ARBORIST Memo

Report Date:
March 3, 2024

Site Address:
3036 67th Avenue SE
Mercer Island, WA

I visited the February 29, 2024 to re-assess Tree #2, after invasive ivy was removed, together with a further assessment of Tree #3, in light of comments from City arborist John Kenney and from neighboring property owners.

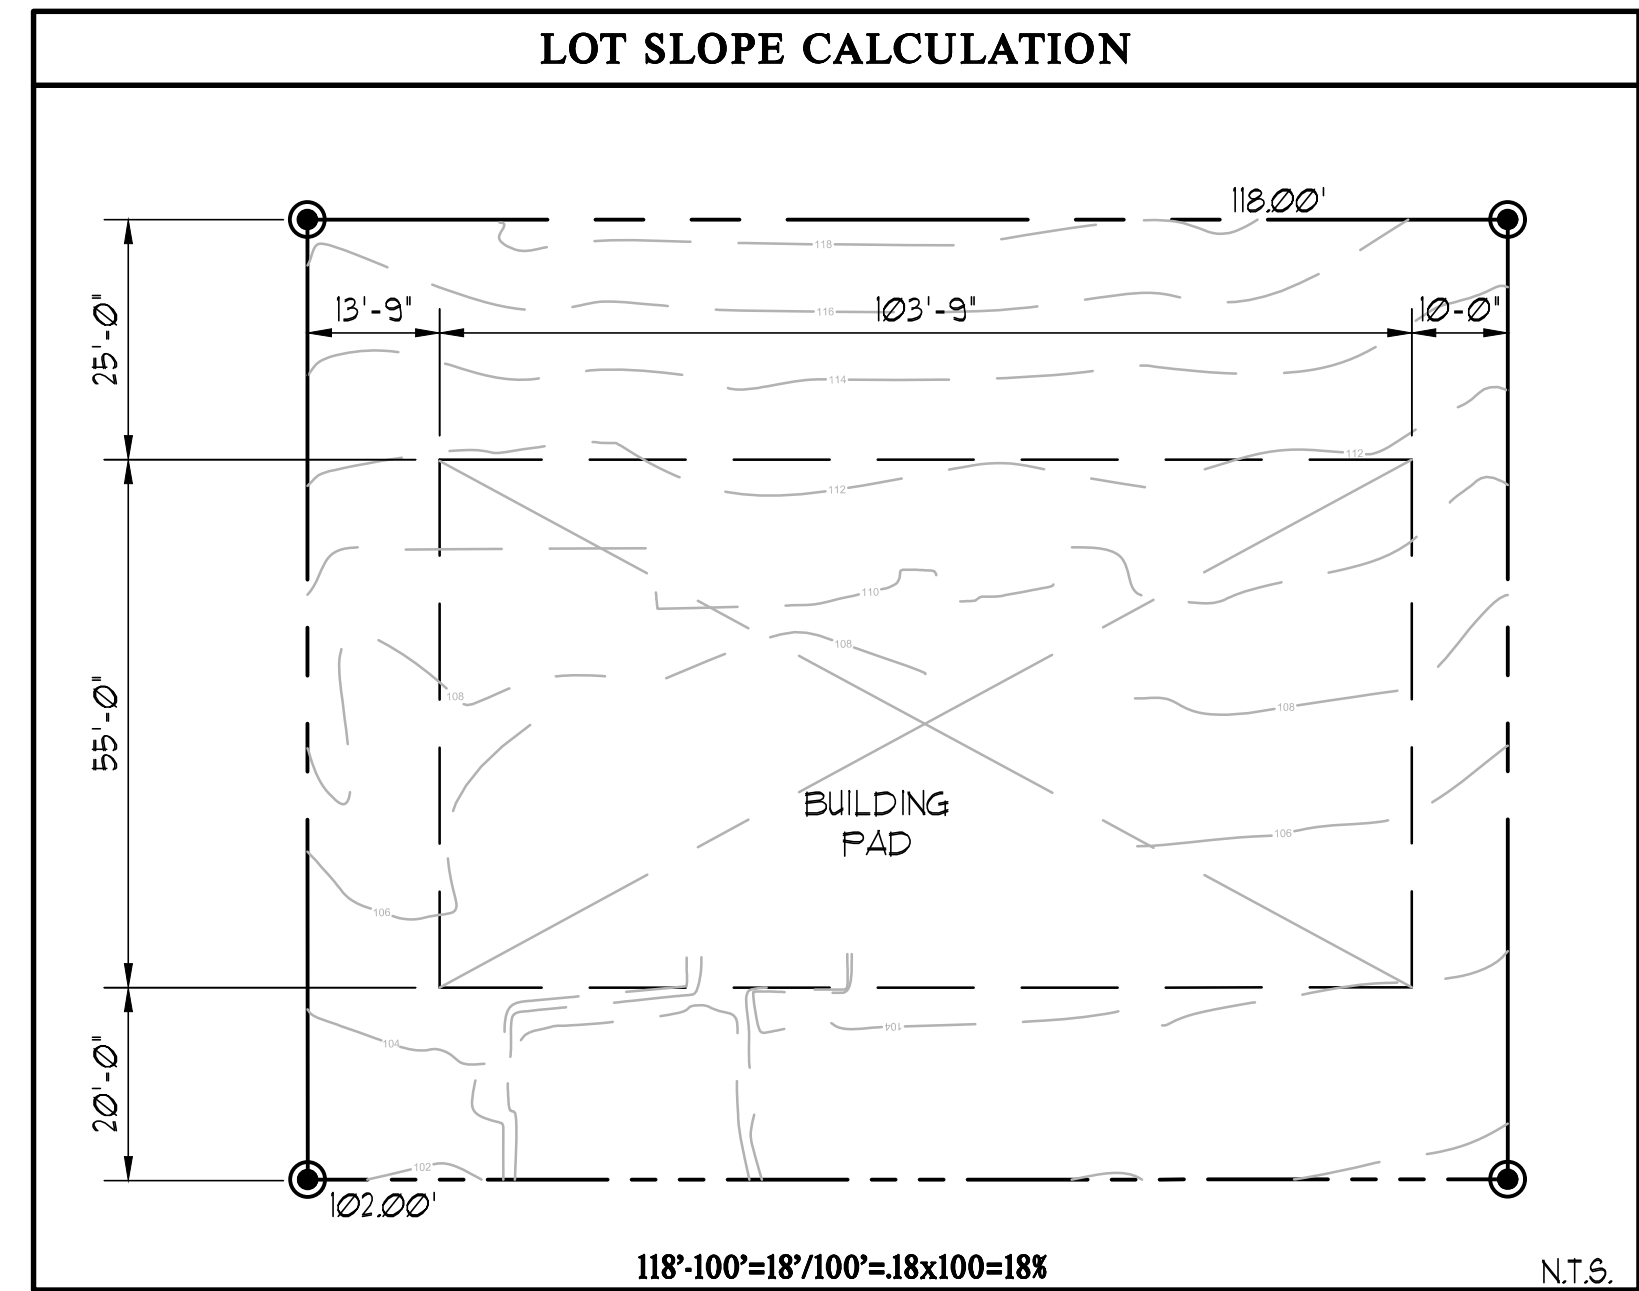
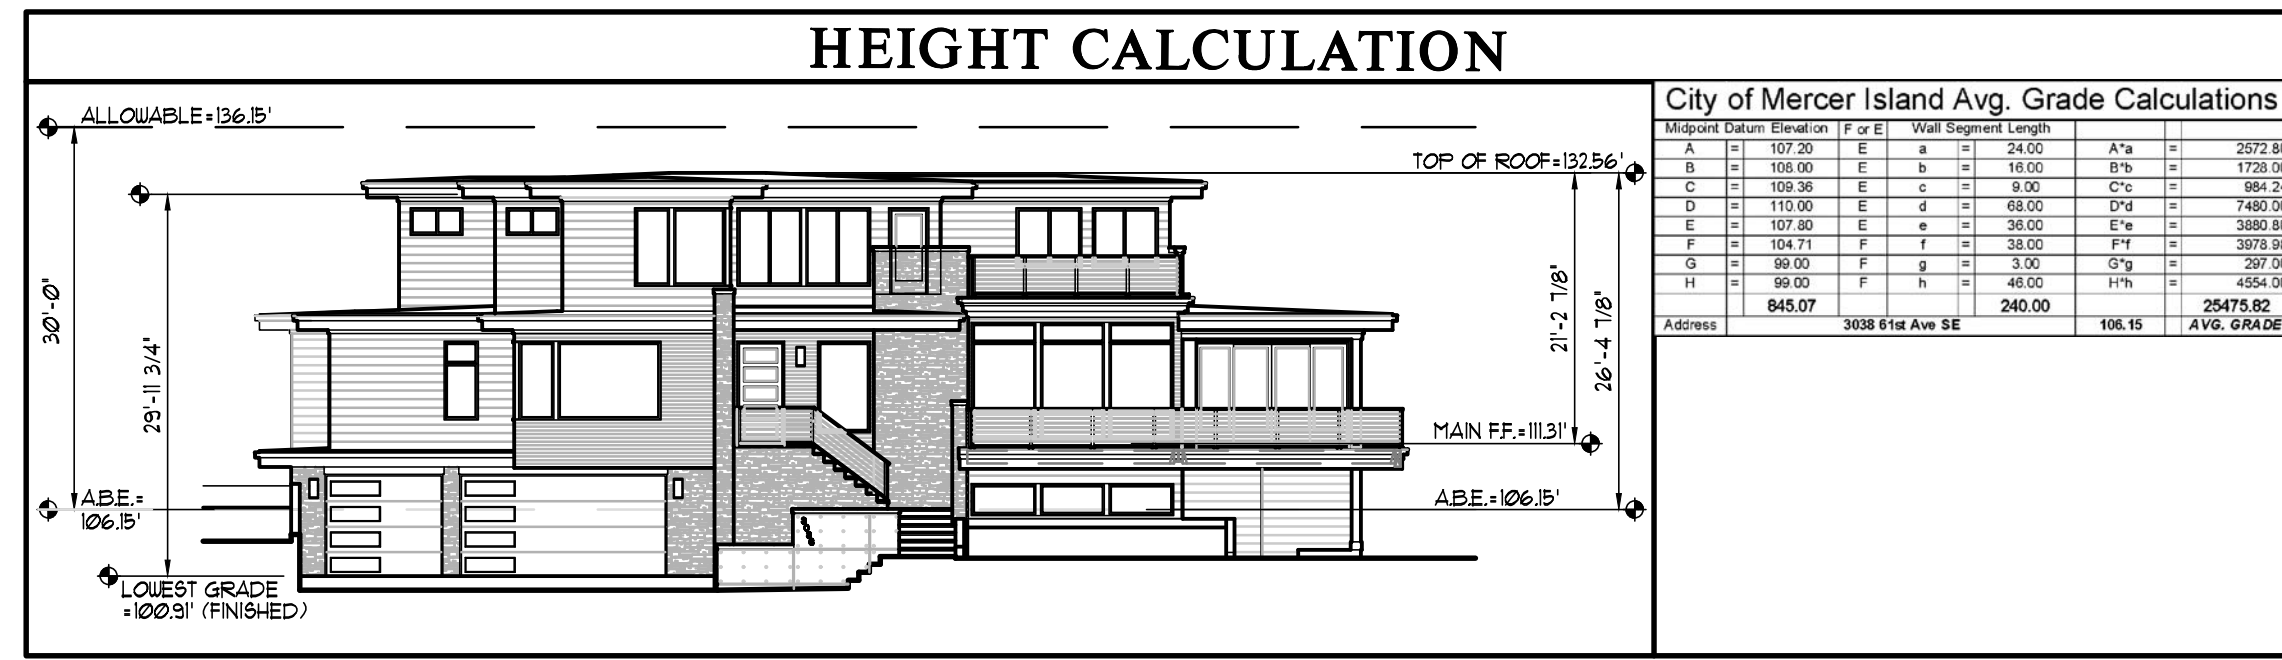
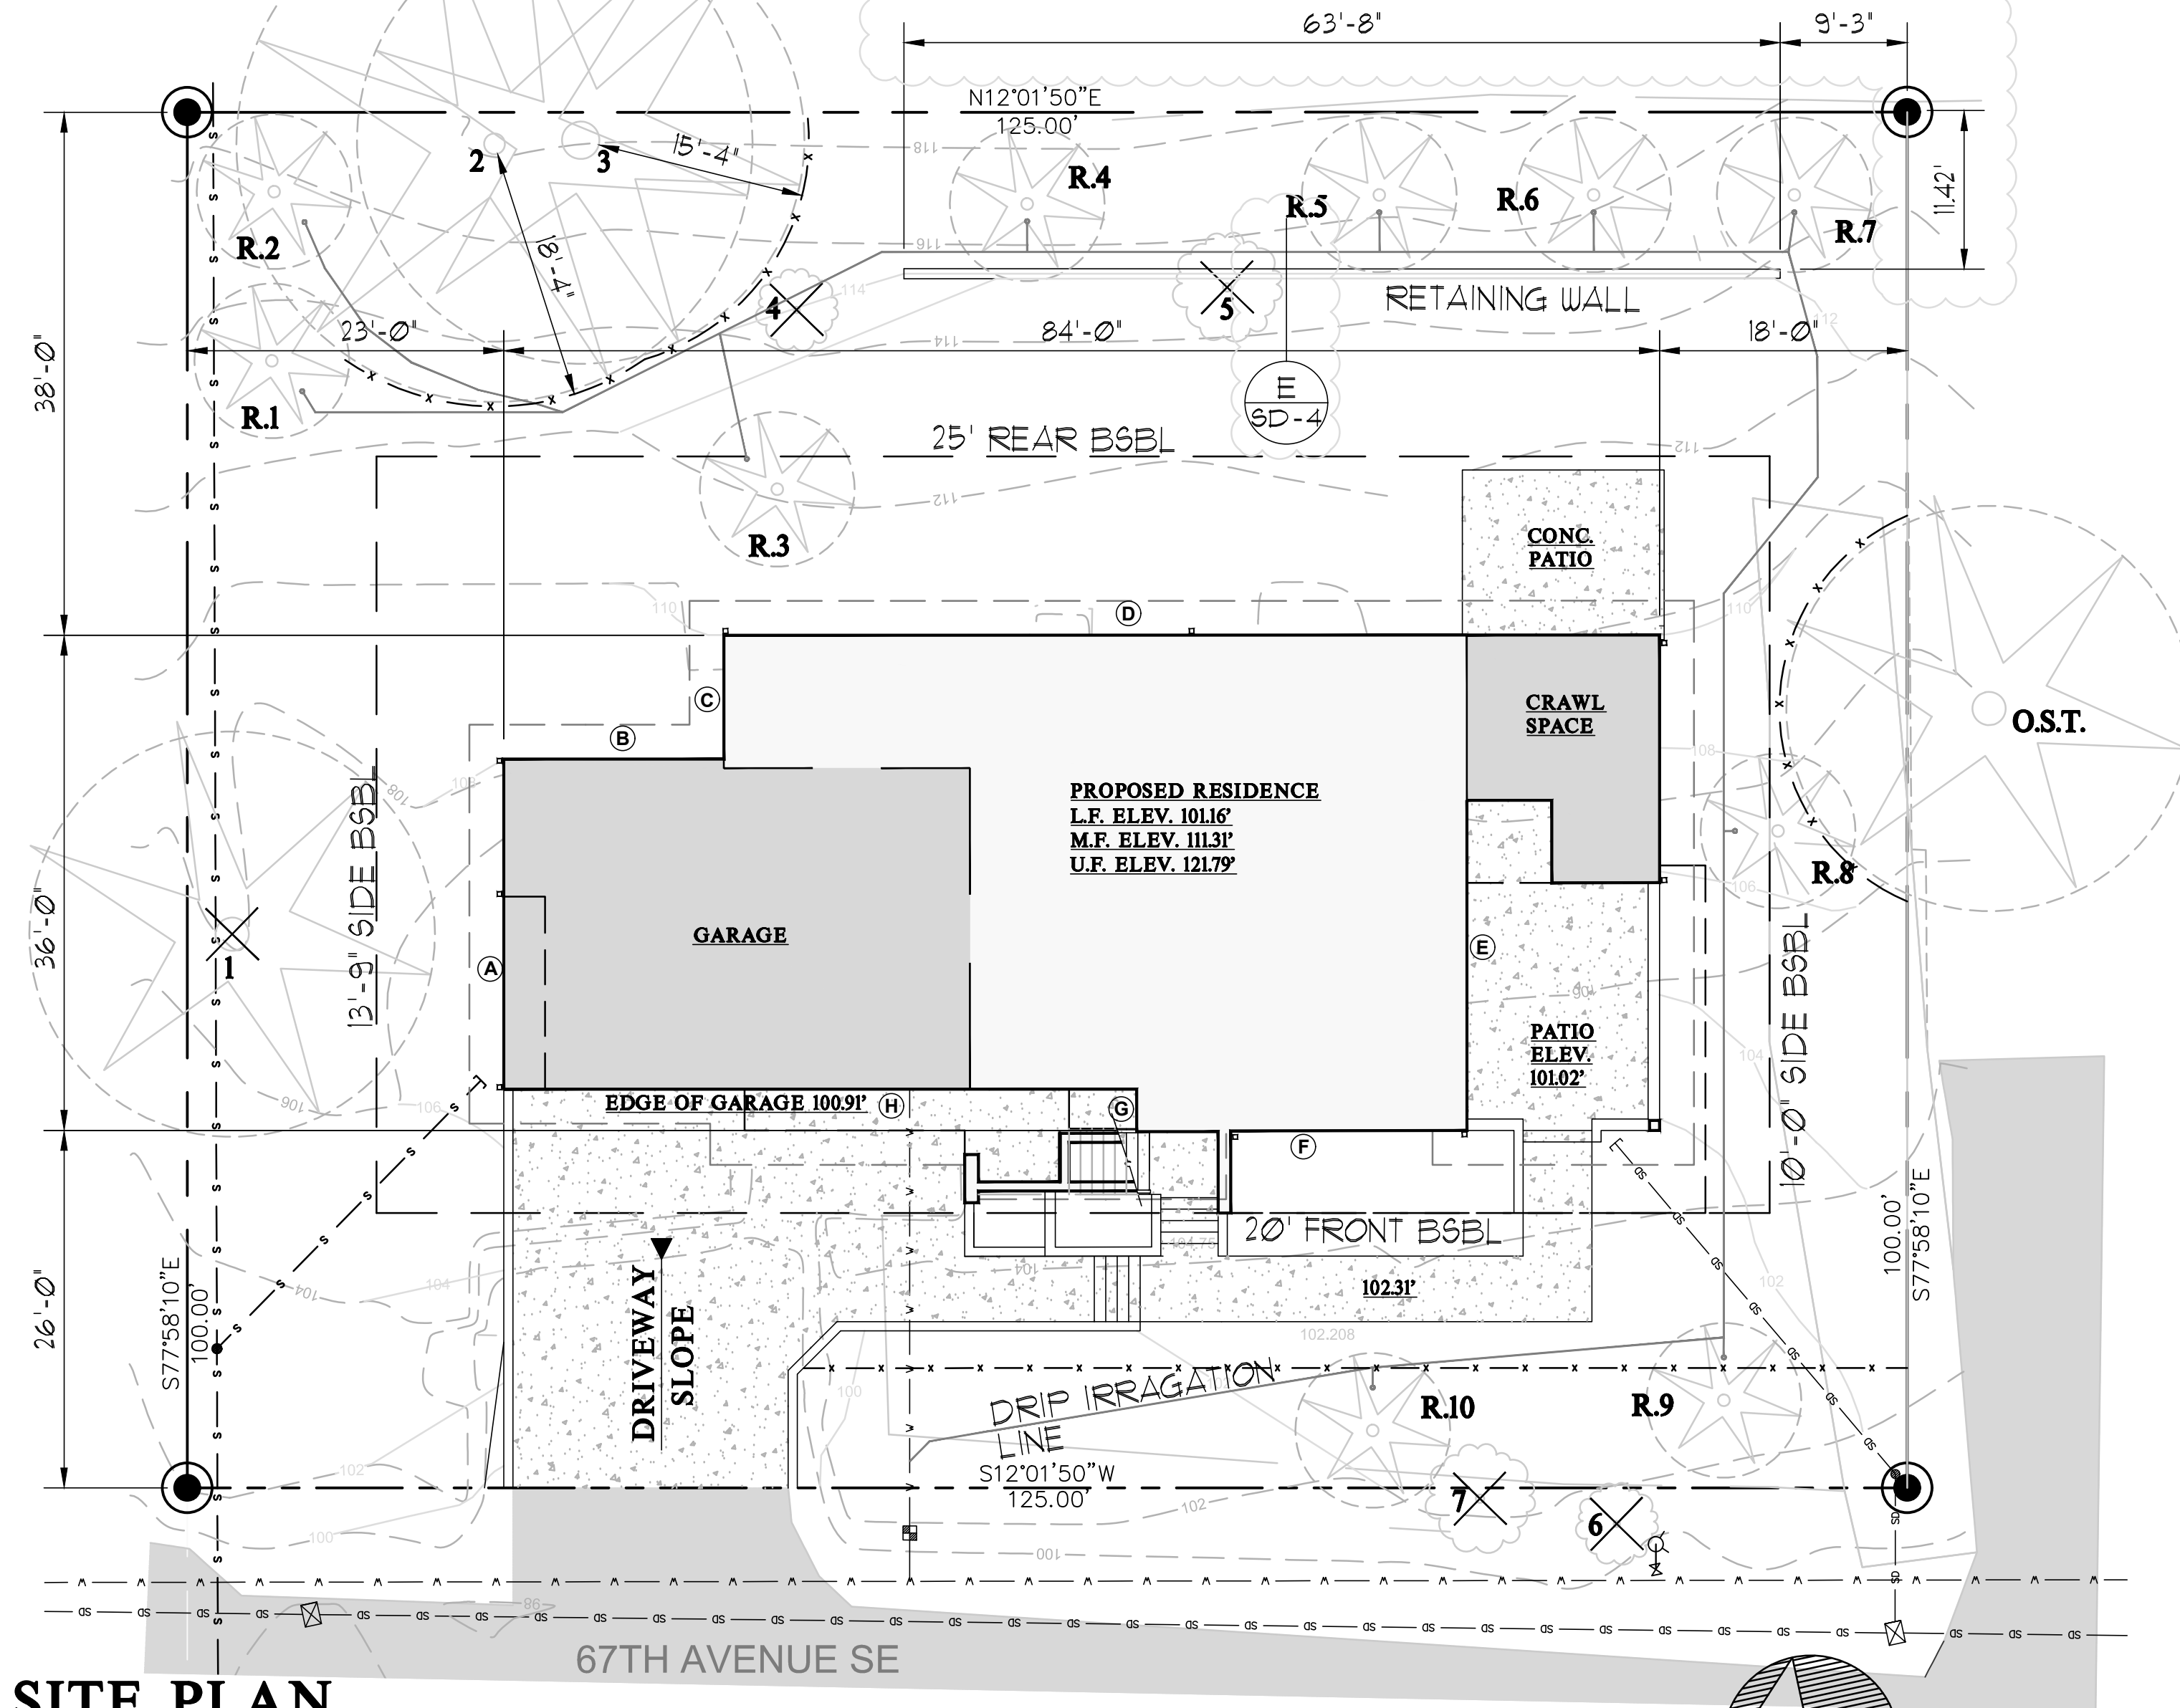
City arborist John Kenney also indicated that I should suggest an alternate species to the planned planting of Western Red Cedar trees in the backyard of the subject property. I have reviewed plan sheet A1.1 and agree that replacing four(4) of the four Western Red Cedar trees with Vine maple will make for happier uphill neighbors and will provide a better planting pallet, long-term.
